**From:** system@affinitylive.com on behalf of Maureen Sidoti  
<maureen\_sidoti@hotmail.com>  
**Sent:** Friday, 18 December 2015 5:32 AM  
**To:** Ashley Cheong  
**Subject:** Submission Details for Maureen Sidoti (object)

My third submissions is an objection on the grounds of AMENITY, or more specifically the way in which the proposals outlined in this application would impact negatively on the pleasant and largely tranquil nature of the heritage environment of the Campbell's Cove foreshore, the Hickson Rd streetscape and daily life within that area as experienced by locals and visitors alike.

Site: #3103 Campbell's Stores

Drawing Title  
**ELEVATIONS**  
JPW Project Number  
12006  
Drawing Status  
EA  
Drawing Number  
EA-A-2000  
Revision  
B

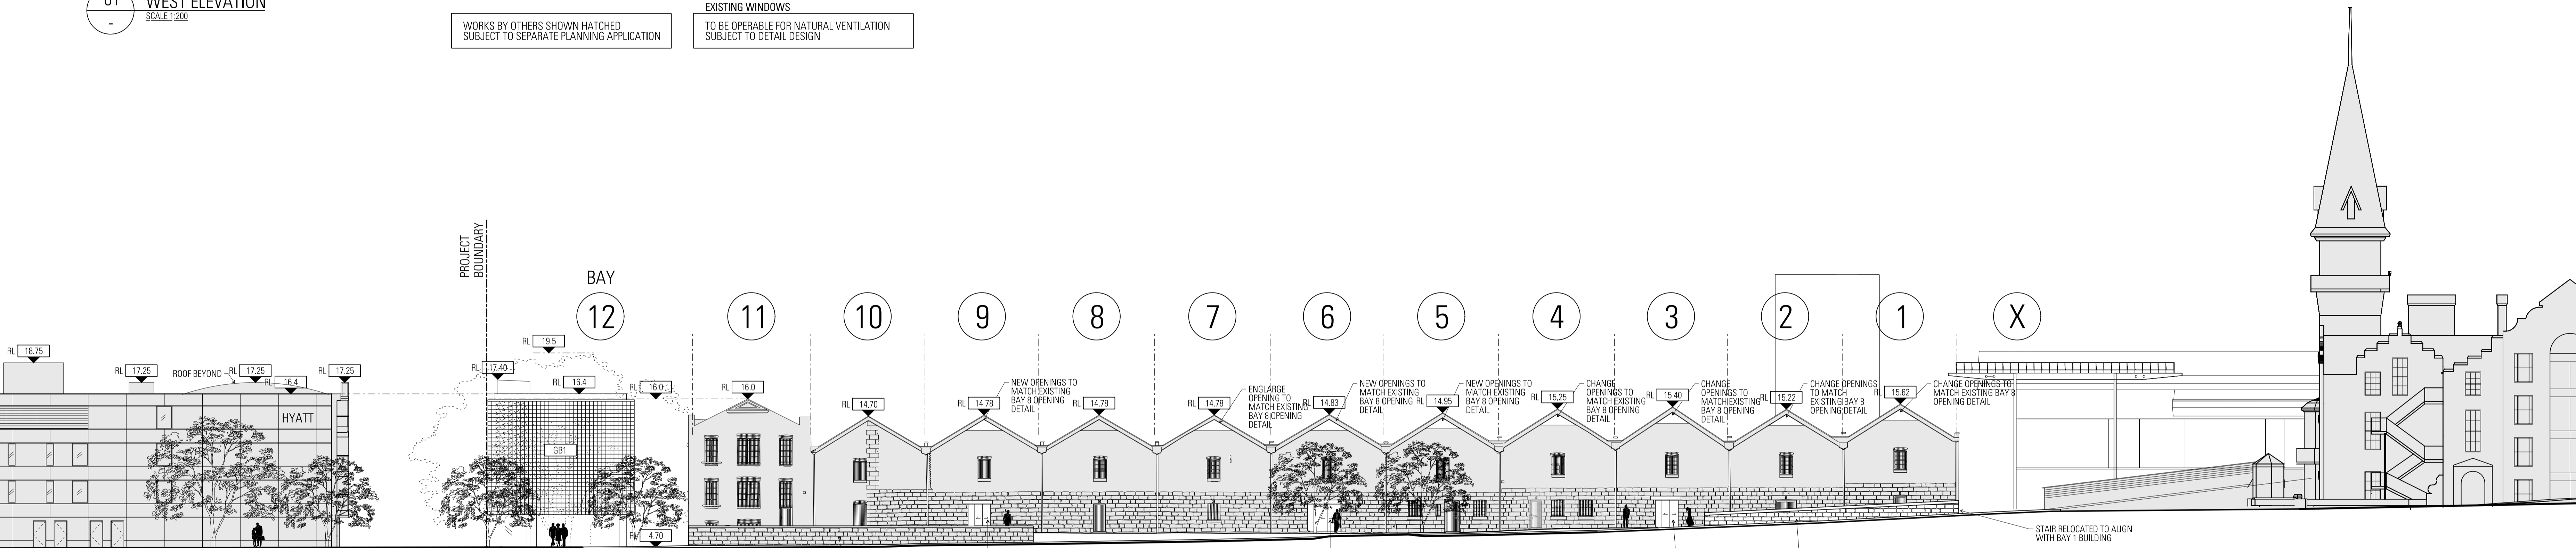
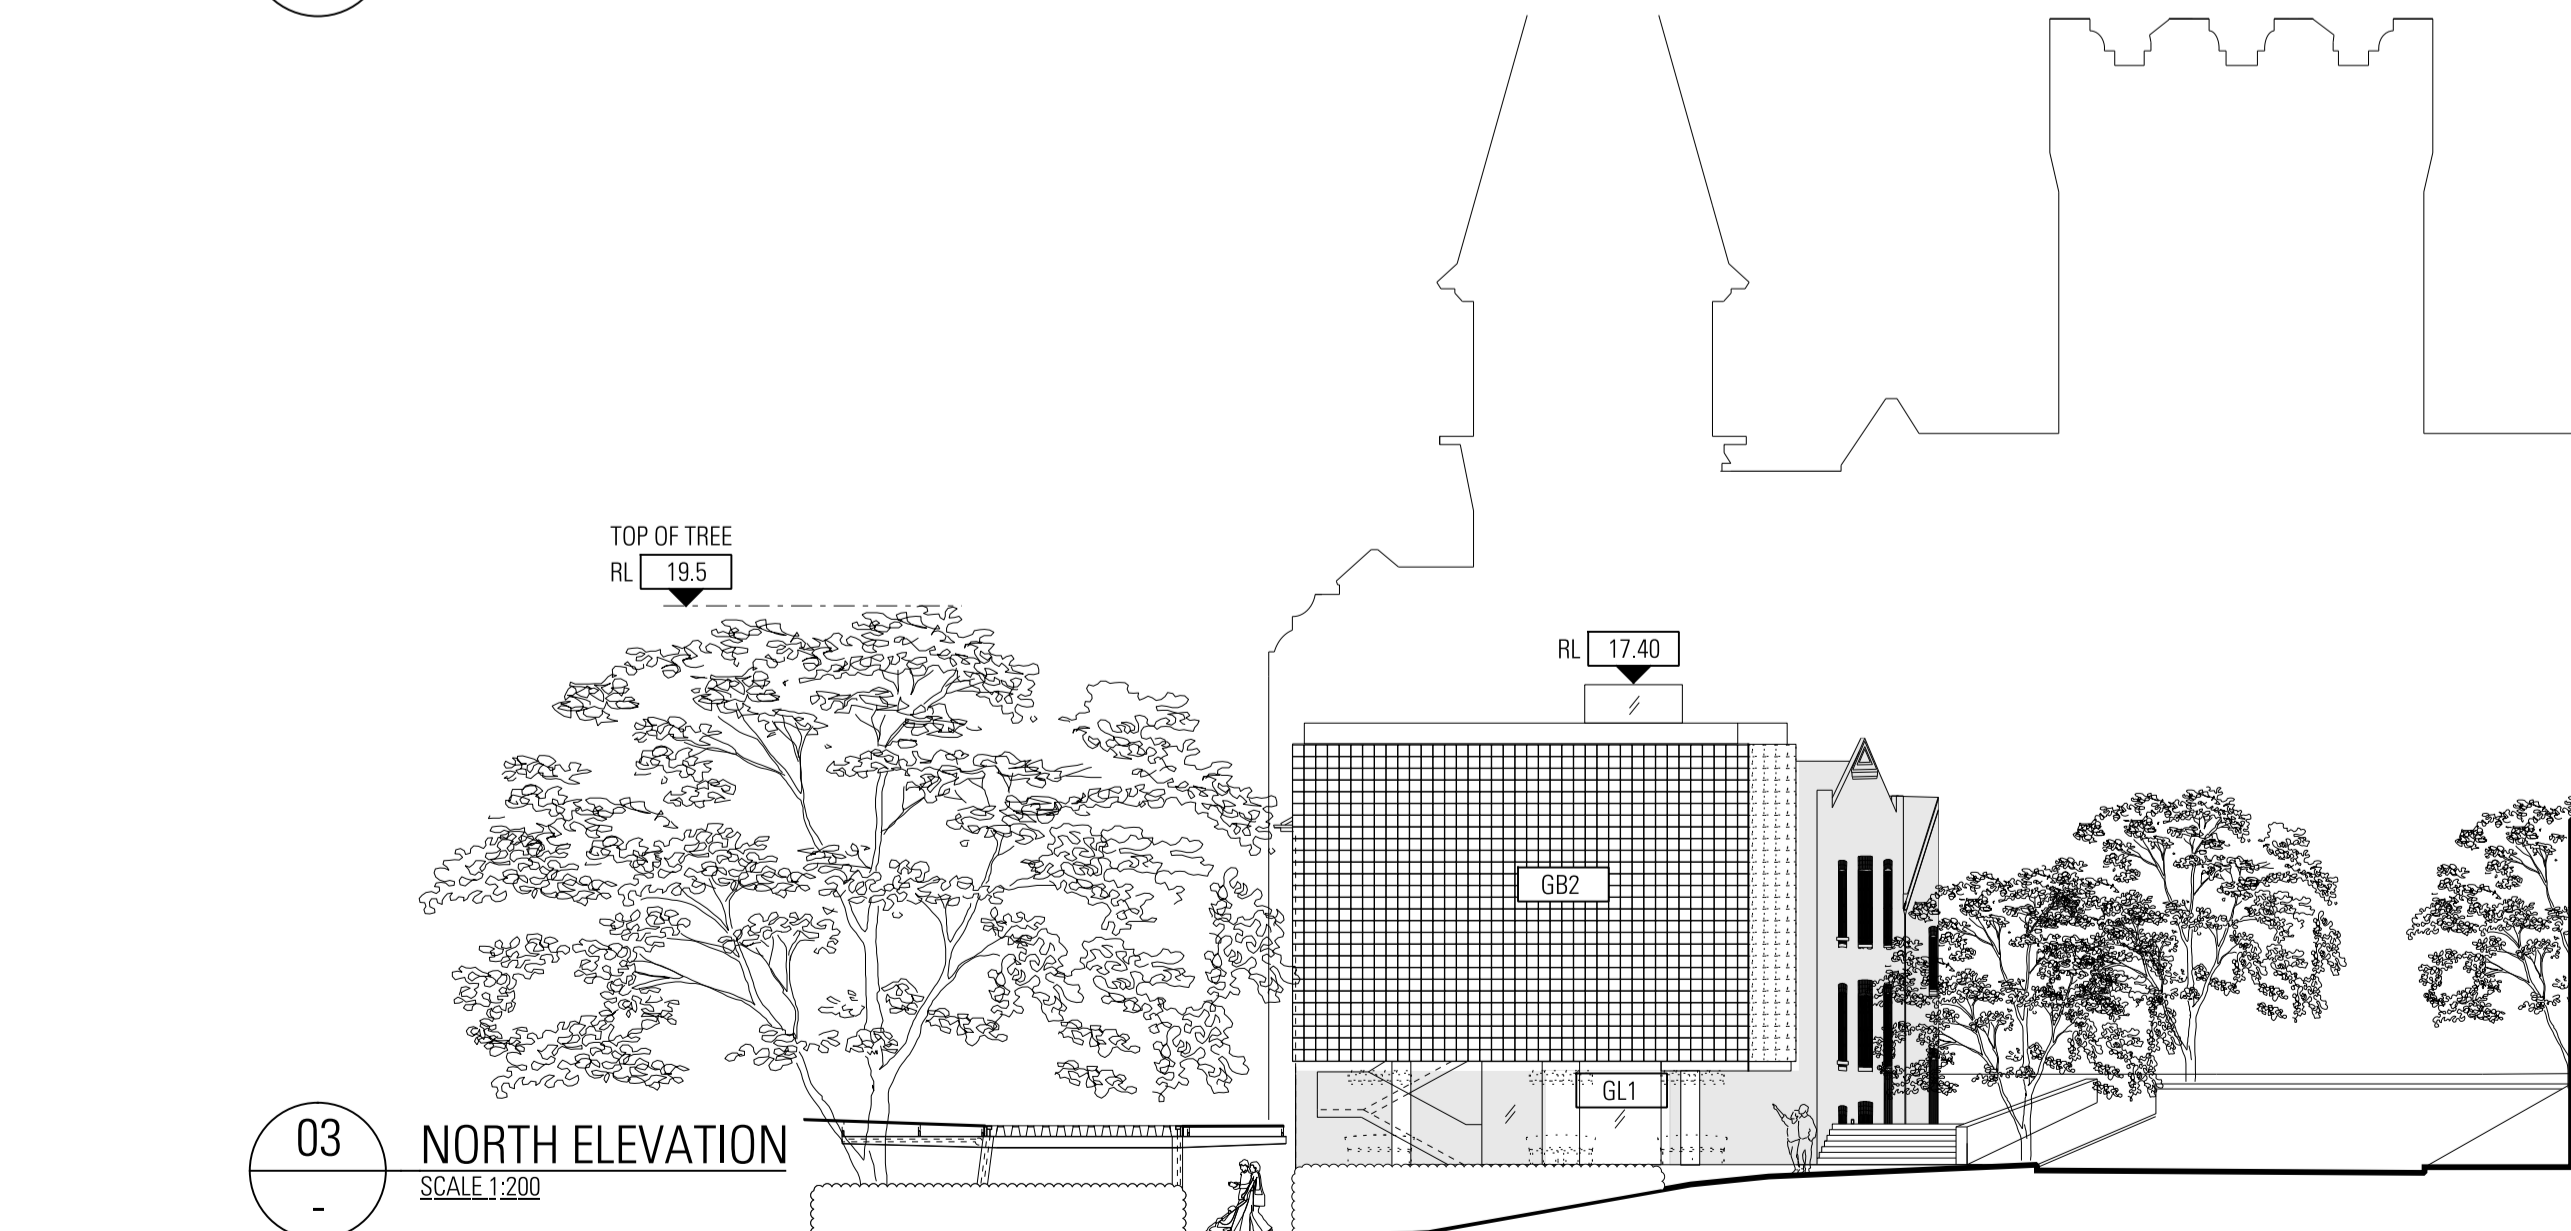
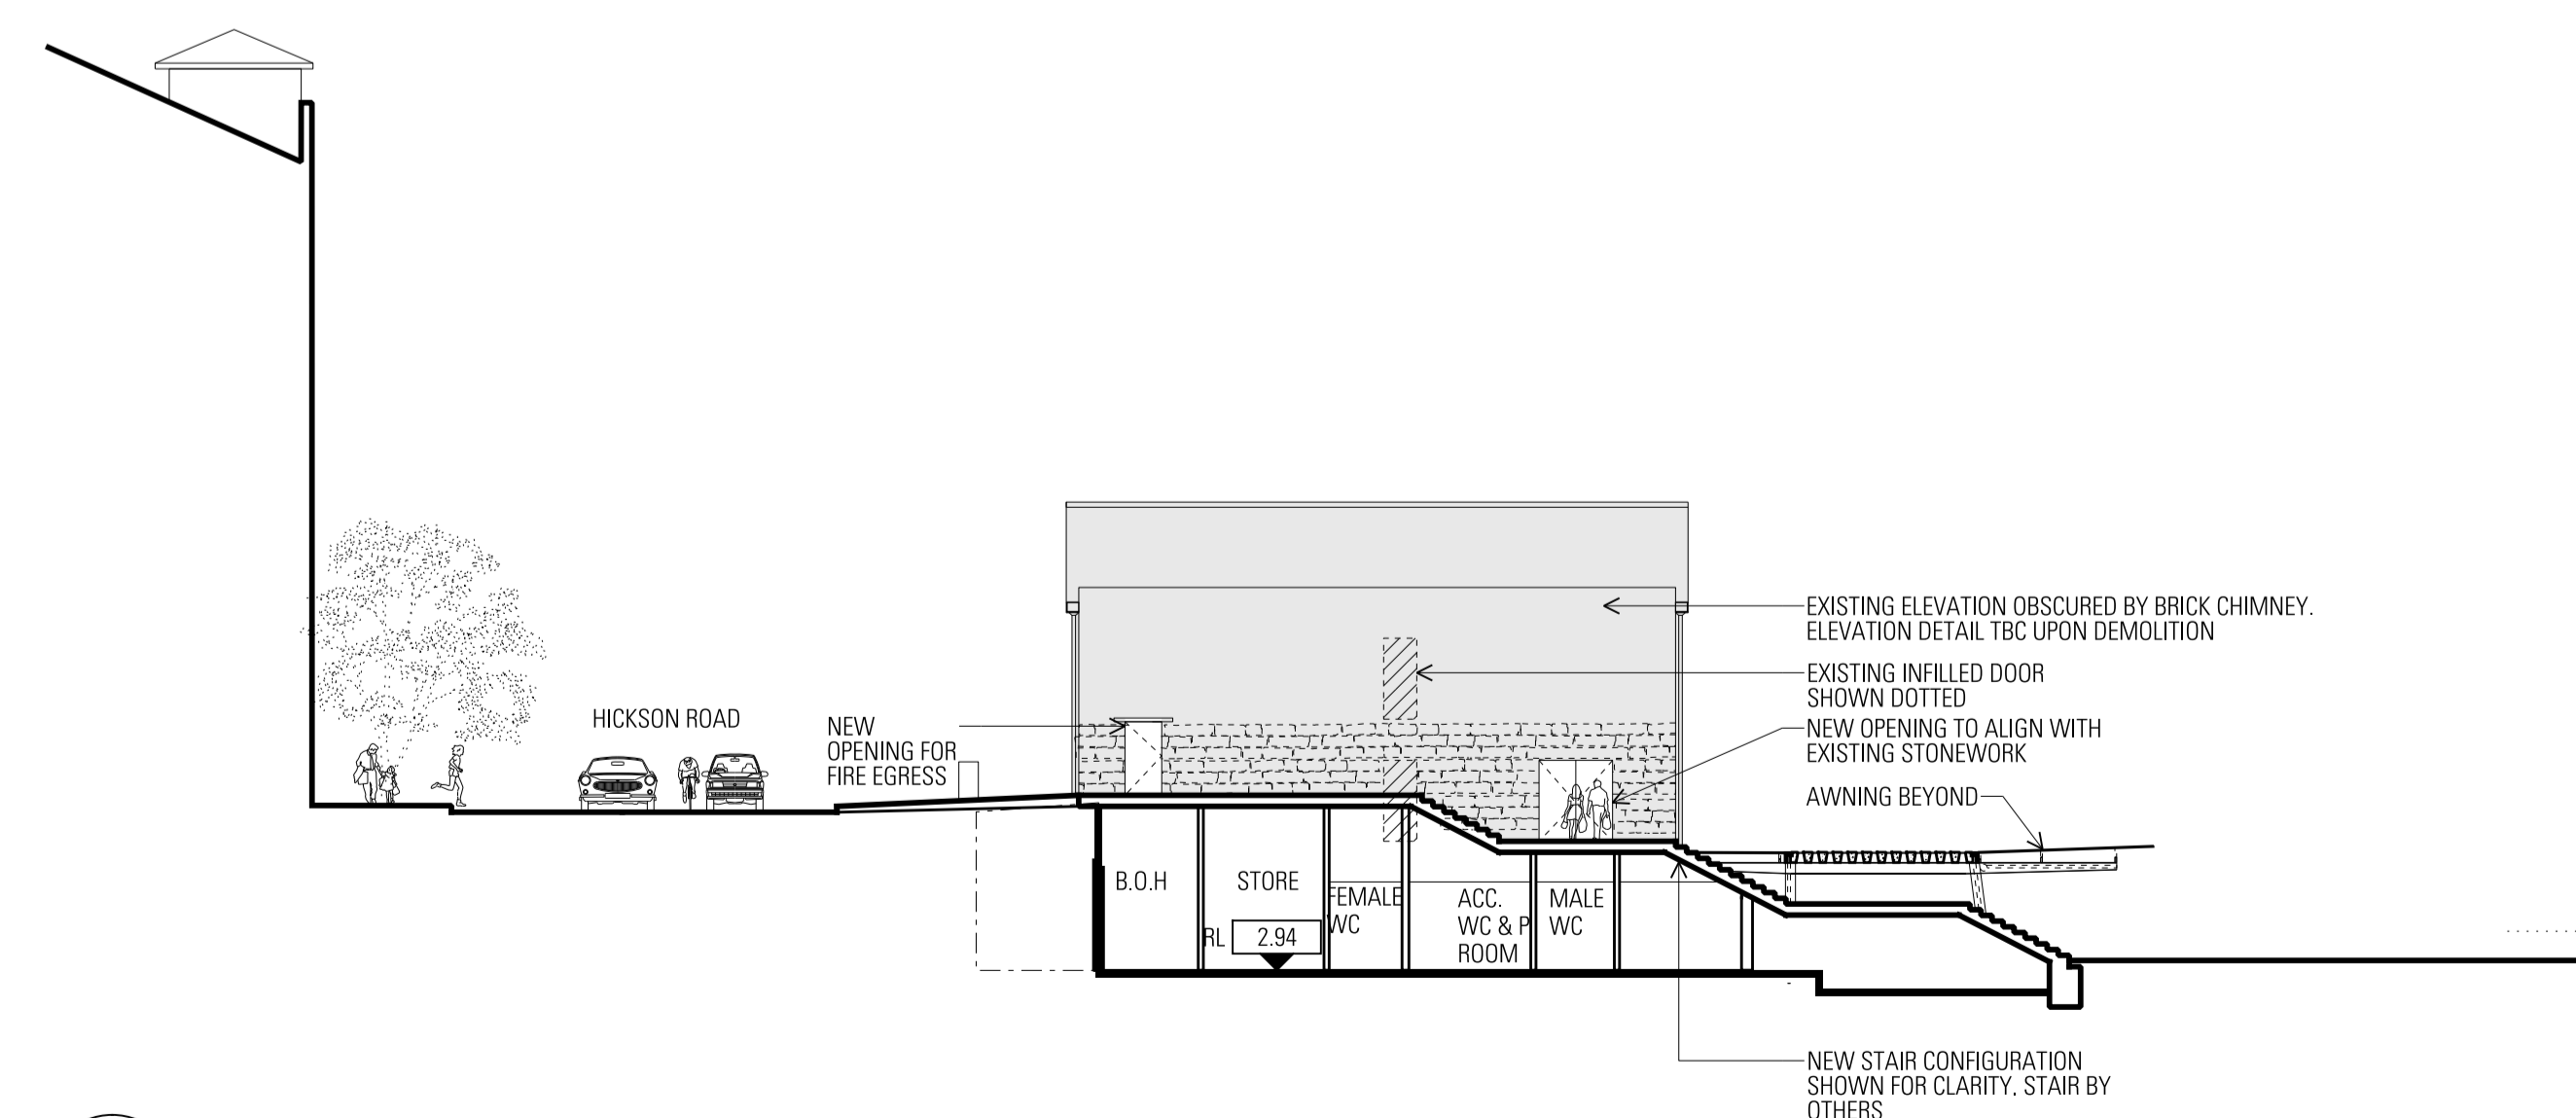
\* The Hickson Rd streetscape is one of largely heritage buildings from George St all the way to Towns Place. The glass box proposed for the northern side of Campbell's Stores would look as though someone had parachuted it in. It would have no visual or aesthetic relationship with the heritage building on one side of it or the sympathetic, modern lines of the Park Hyatt Hotel on the other.

\* The glass building would have the appearance of a tall and bulky glass box on stilts. It is the worst of the applicant's proposals and would substantially contradict the heritage environment of Hickson Rd and the Campbell's Cove foreshore.

\* When measured from a new raised ground level, the glass box would be 13.3 metres high with the inclusion of its 1 metre high lift overrun. This exceeds the current height restriction on the foreshore frontage by 14.5m, i.e. by more than 250% and on the Hickson Road elevation by 10.5m, or 140%. It would be a full storey higher than Campbells' Stores' gutter with the lift overrun making it higher again. (Design Statement diagram p.96). It would be higher than the Park Hyatt Hotel alongside it. Building plans suggest that the way has been left open for further expansion in the future.

\* Given this height and bulk, the proposed new four-storey glass box would dwarf the heritage-listed Stores, dominate the Campbell's Cove foreshore and be the tallest building on this side of the Hickson Rd streetscape.

\* Currently, when walking south along Hickson Rd, we can see the upper two storeys of Campbell's Stores' northern end. The box would hide the entire building and 'bury' its ground floor under a new, nearly 2 metre higher, ground level so as to accommodate a basement area for the glass box.

\* The glass building's minimal 2.5 metre undercroft would feel oppressive and tunnel-like. This, along with its intended use as an outdoor eating area, would serve as a barrier that locals and visitors would have to pass through before any views of the Opera house would emerge. As someone said recently, this 2.5 metre high undercroft would make existing views of the Opera House seem like 'looking at it through the slit of a letter box'.
